APPROVED
Limited liability only review
Permit holder responsible for
full compliance with the code

07/18/2022

**RESIDENCE OF
JAMES & NICOLE CALLAHAN**

FOUNDATION PLAN
SCALE: 1/4" = 1'-0"

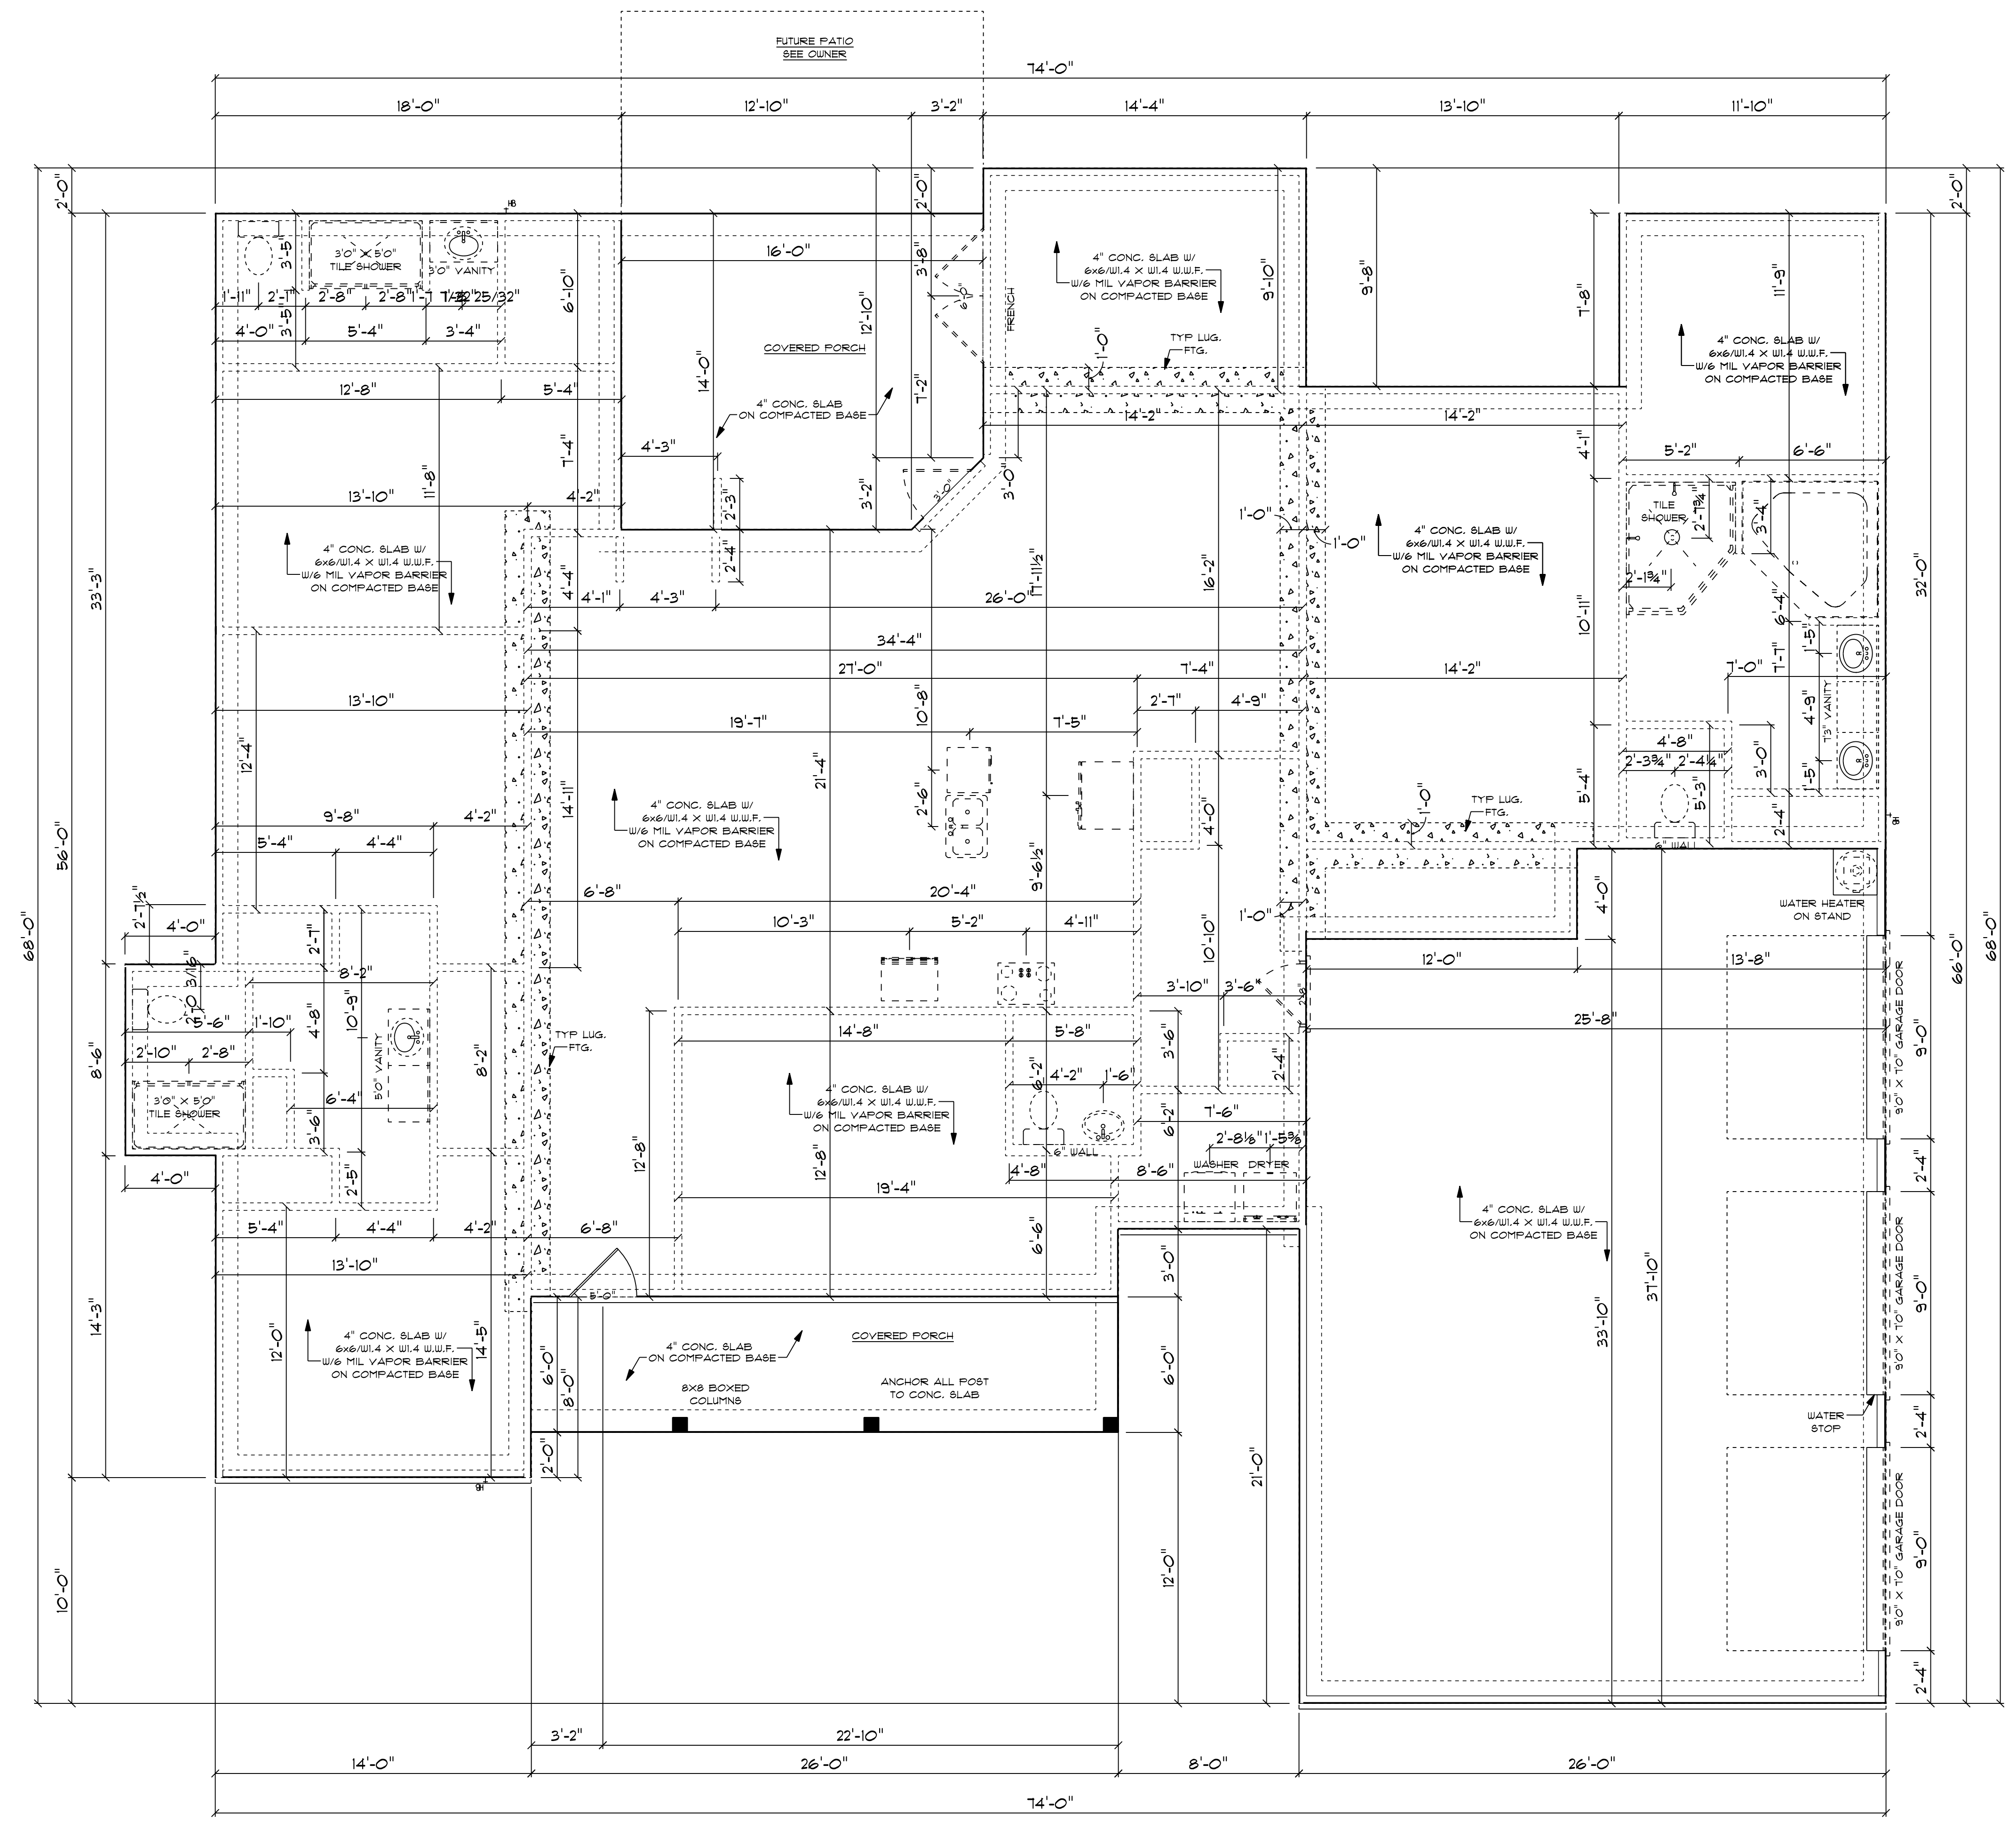
No garage door beam information provided. This will need to be at jobsite prior to footing/inspection to verify point loads
